**Concord Hospital Concept Proposal & Stage 1- Modification 4 (SSD-9036-Mod-4)  
Request for Additional Information**

I refer to Modification 4 for the Concord Hospital Concept Proposal and Stage 1 (SSD-9036-Mod-4). After careful consideration, the Department is requesting that you provide updated architectural plans that clearly show the proposed design changes.

TITLE
ELEVATION - NORTH & SOUTH

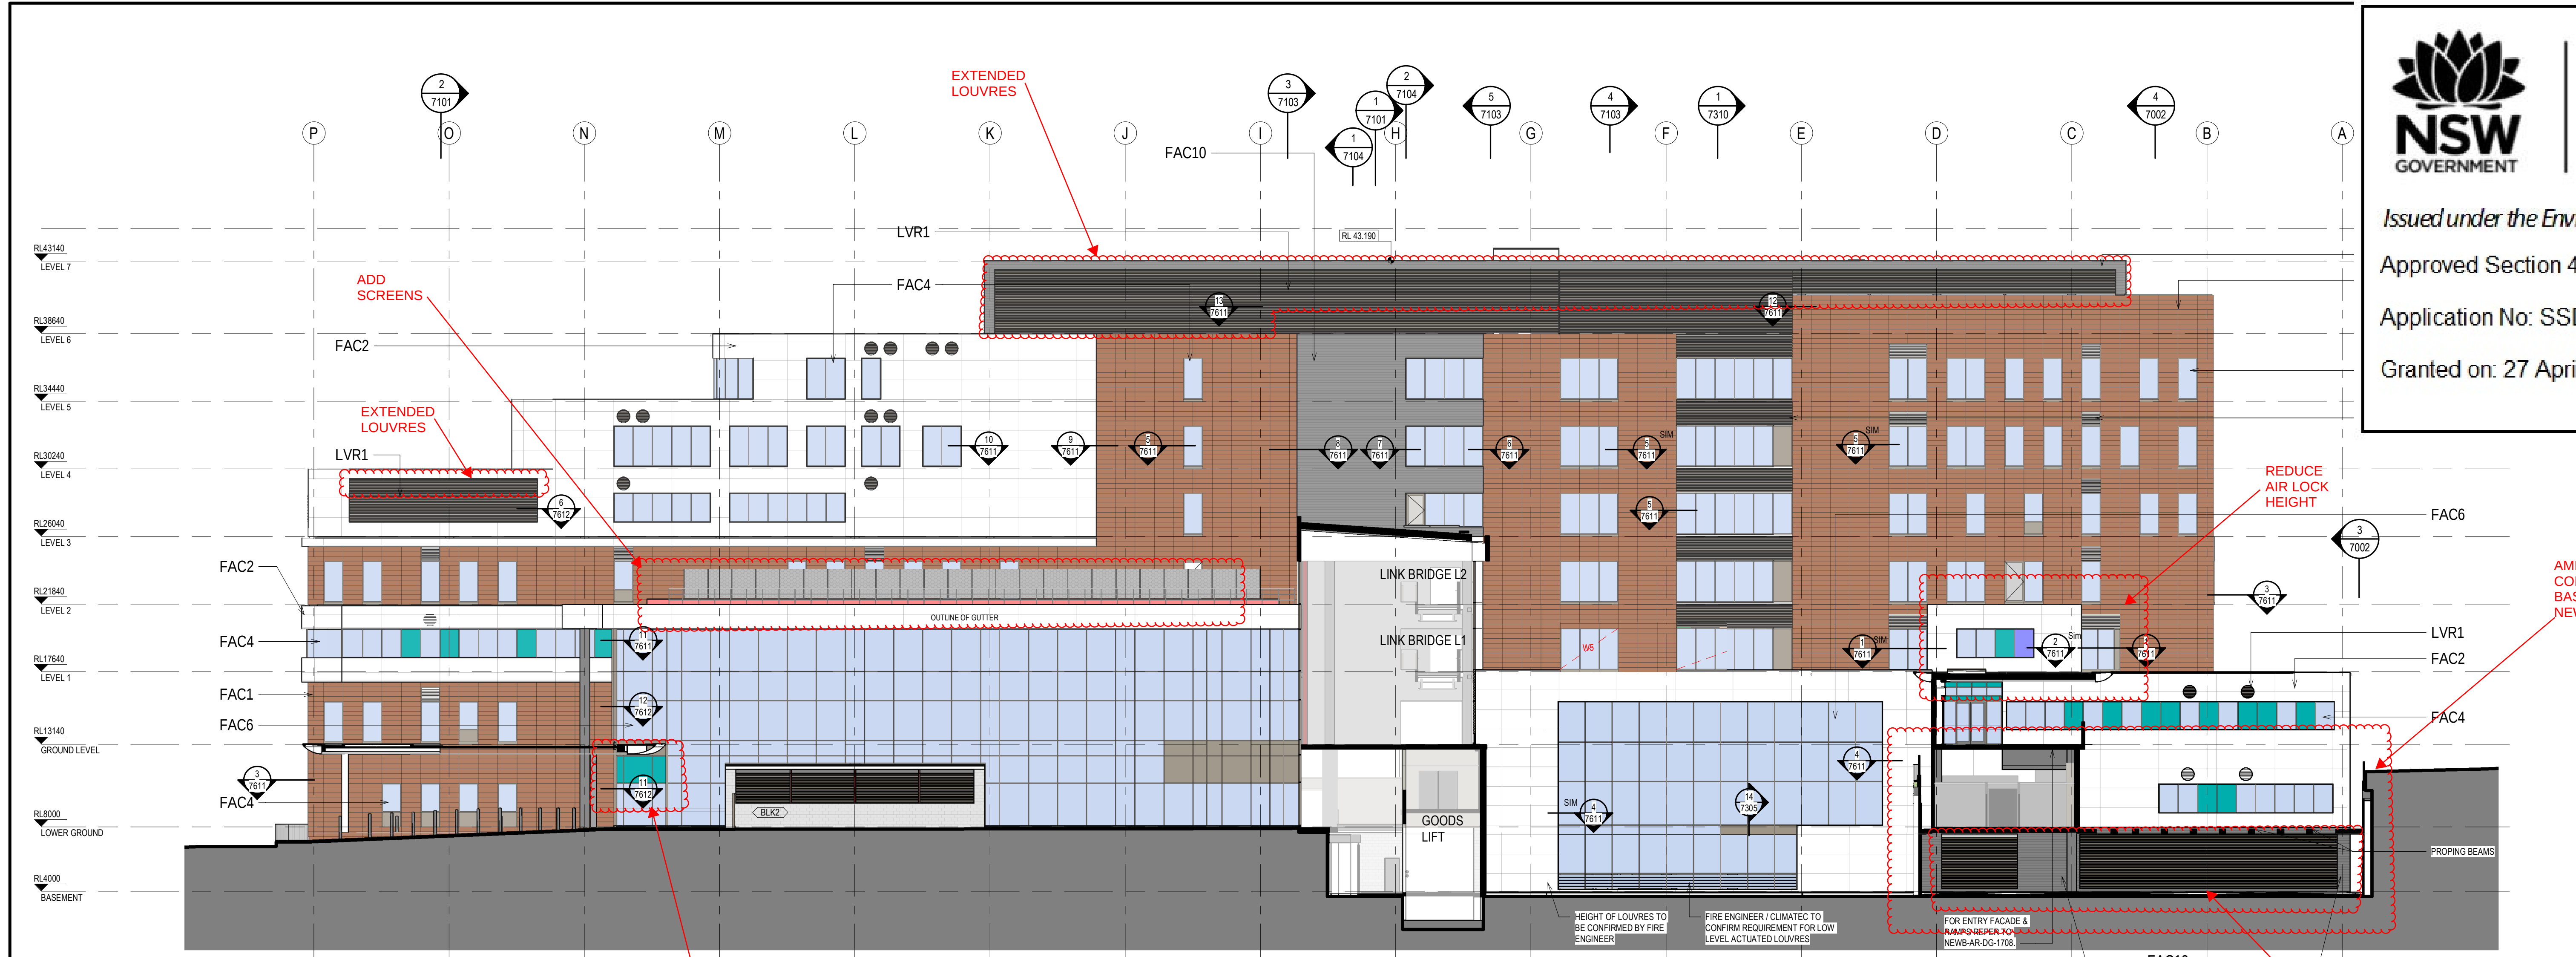
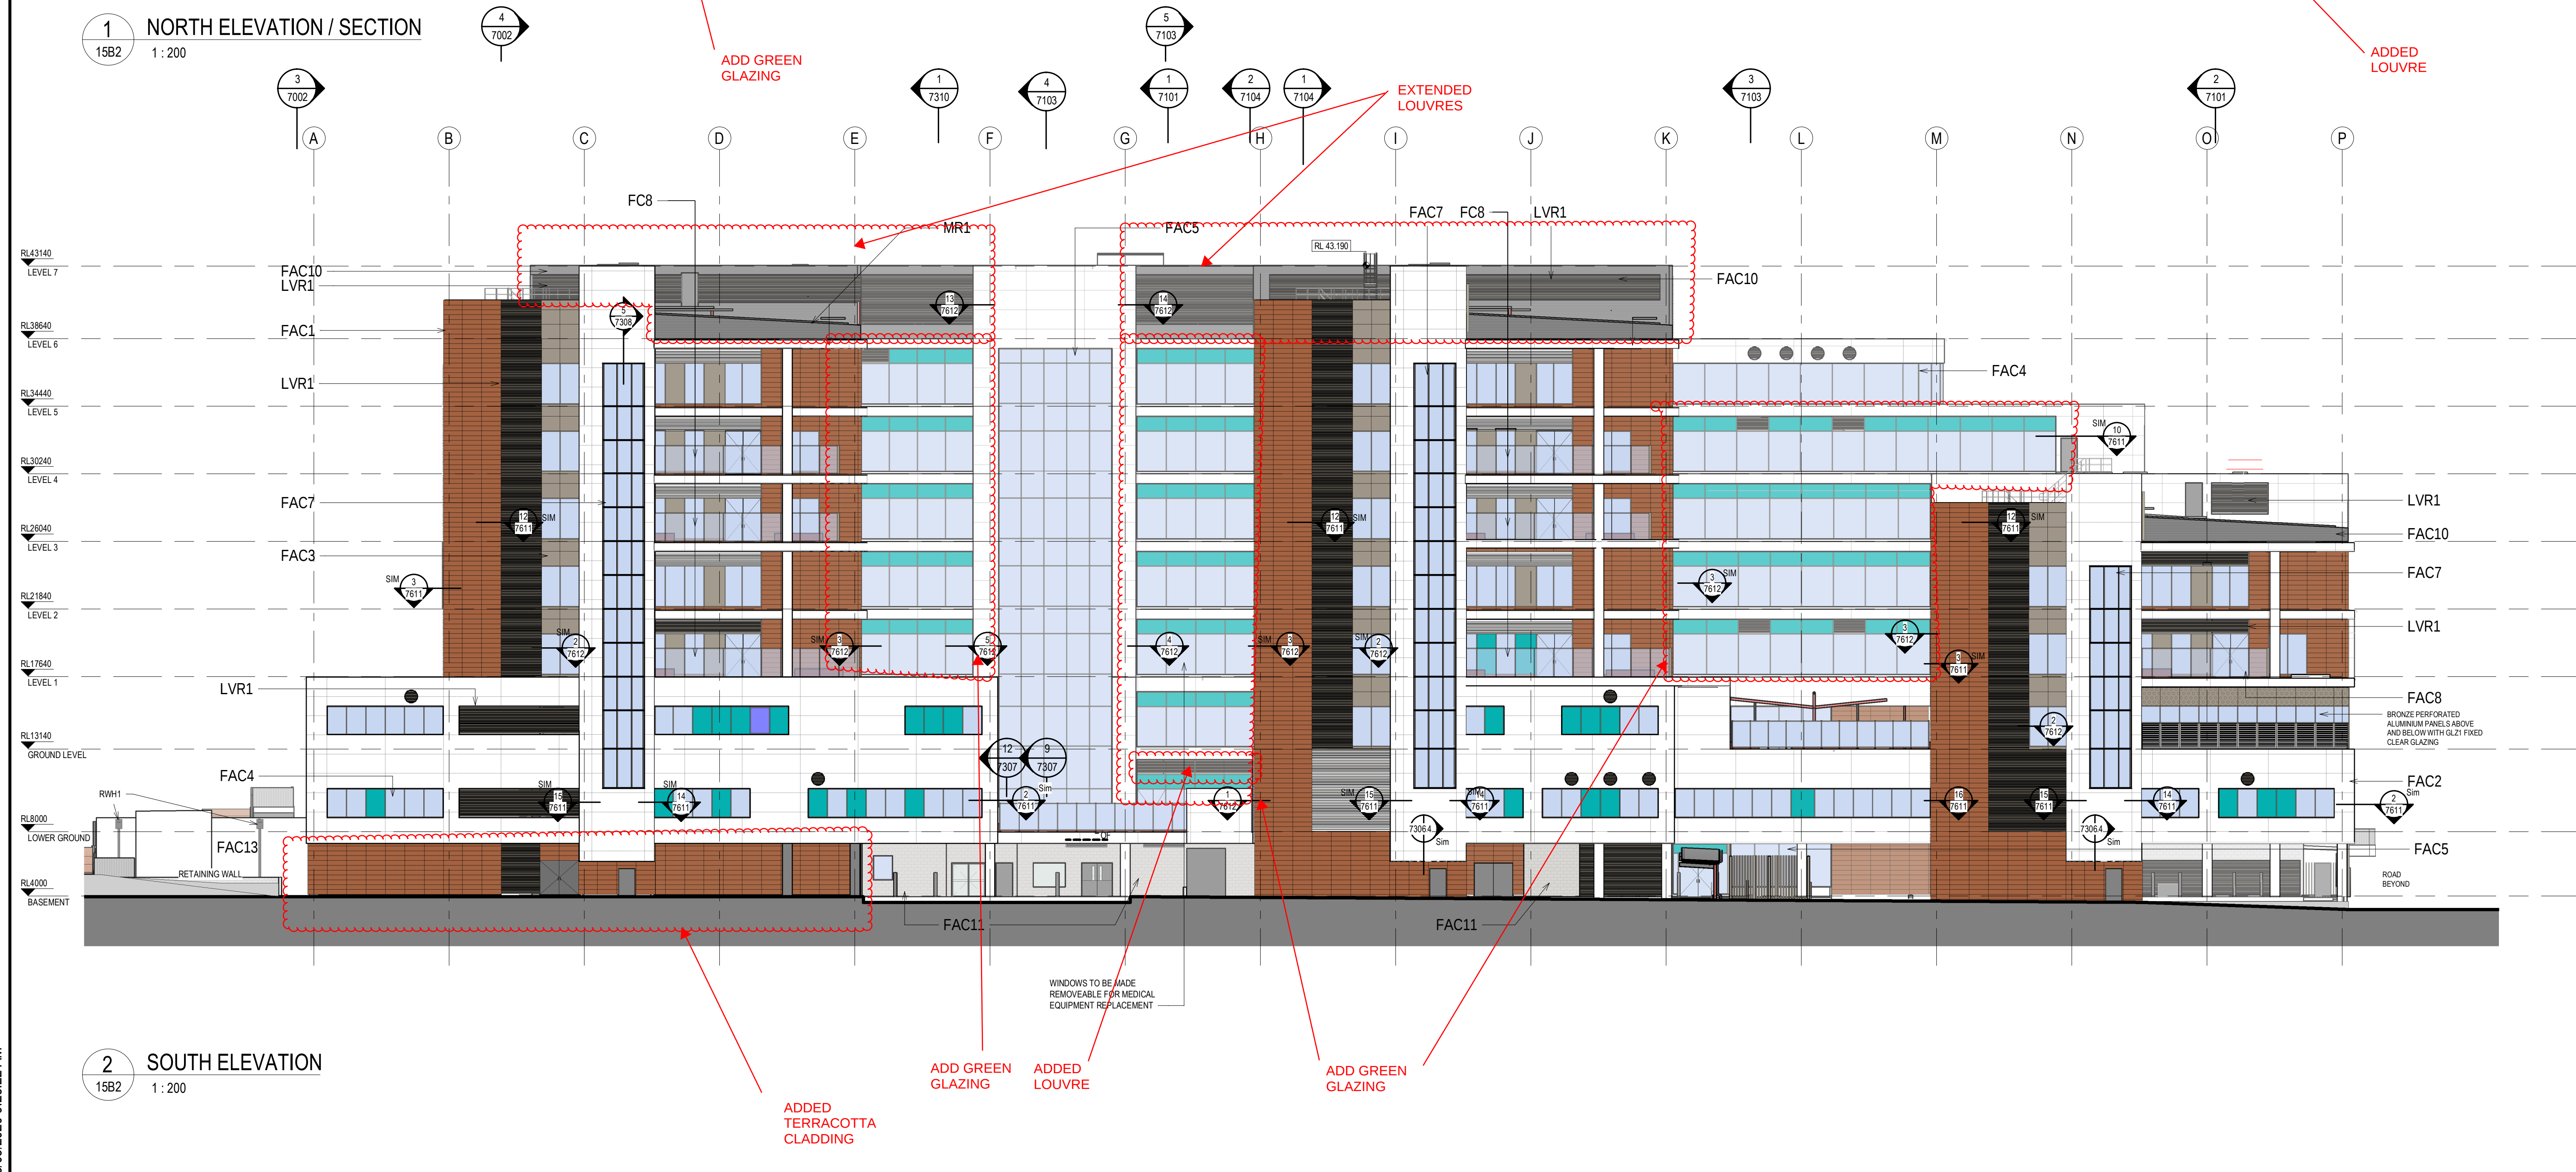
- Elevation North & South.
- Elevation East & West.
- IPU 1 East & IPU 2 West.
